Subject: AB/4/22/L - Conversion of loft to habitable use including installation of 3 x dormers and roof terrace, addition of rendering, and alterations to fenestration/openings -Mews House, London Road, Arundel

Section 72(1) of the Listed Building Act 1990 applies so that the **Arun District Conservation Area Advisory Panel** would appreciate the same comments that it made in respect of the planning application also being taken into account in the determination of the above application for Listed Building Consent. The comments are:

EAST ELEVATION PROPOSED

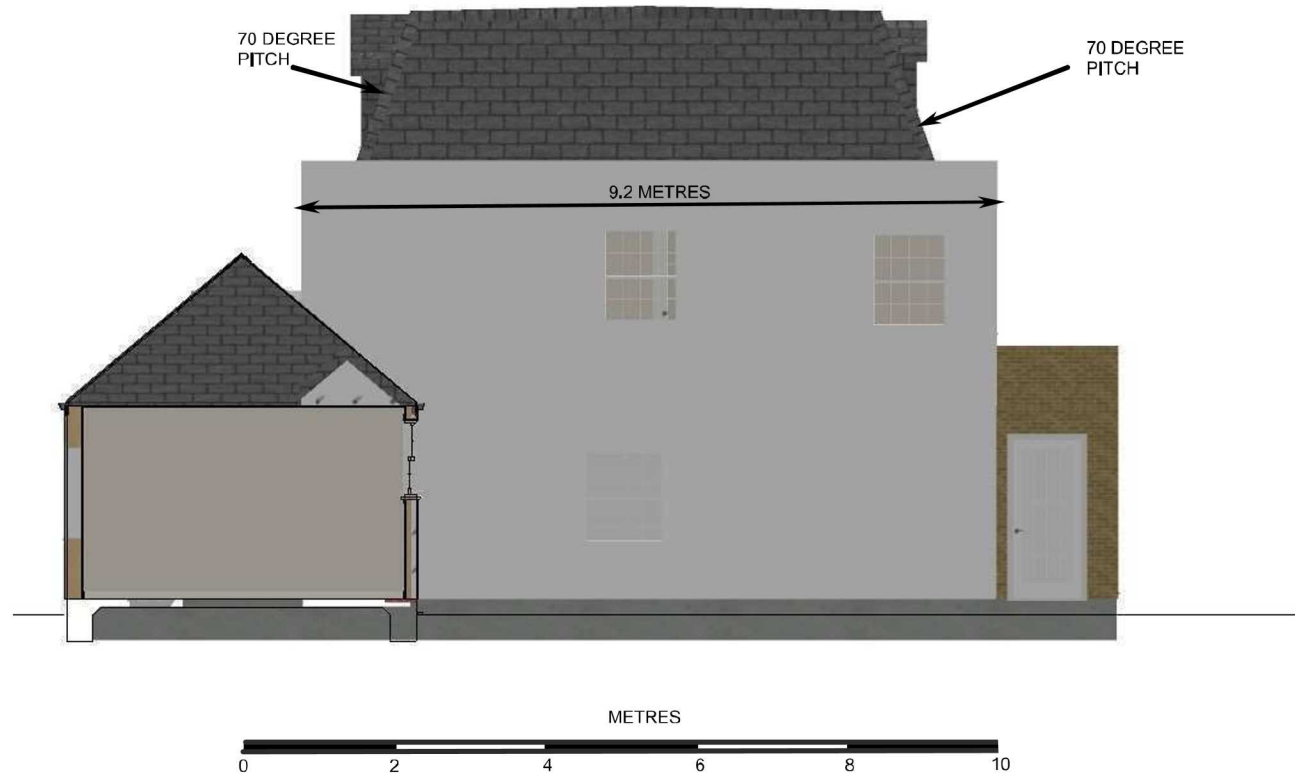
The intended new 'mansard' roof is not only oddly asymmetrical but simply does not suit the particular design of the property. In addition, the formation of a screened roof terrace next to it will exacerbate the incongruous nature of the proposals which will materially detract from the appearance of the building, the settings of the adjoining and nearby designated heritage assets and the character and appearance of the conservation area. The proposals will also alter the scale and nature of the building, detracting from its heritage significance as an historical ancillary, modest, and visually subservient structure to Tower House.
